AMENDED PLANS
F.A.O.
ALEXANDRA
COTTON

2011/1168

Address: Lincoln House, 7 Barnsley Road, Brierley, Barnsley, S72 9HT

Proposal: Erection of a two storey side and rear and single storey extension to dwelling

PROPOSED FRONT
NORTH

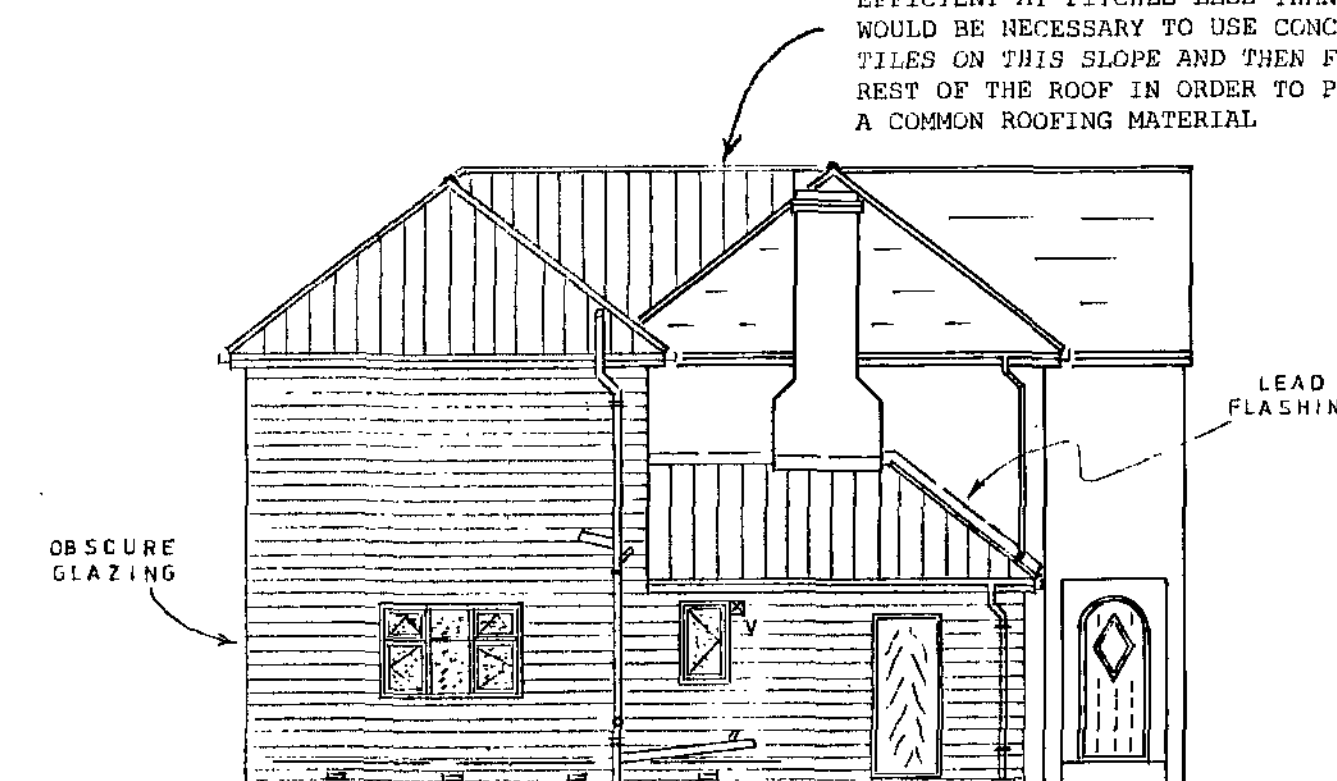
- A window is inserted in the front elevation of the store to match that which is proposed in the bathroom.
- The detail of the windows serving the bathroom and store should be amended to match that which is present on the other windows in the front elevation of the property (i.e. top openers and lead detailing).
- Pitch of the roof of the single storey front extension should be redesigned to match the pitch of the main house, although the preference would be for this roof to be hipped.
- Window in the side elevation of the extension serving the lounge to be removed, reduced in size and obscure glazed or redesigned so that it is a high level window with a windowsill that is at least 1.7 metres above the floor of the room.
- If possible, reduce the height of the roof of the two storey element of the extension so that the ridge is clearly lower than that of the host dwelling.
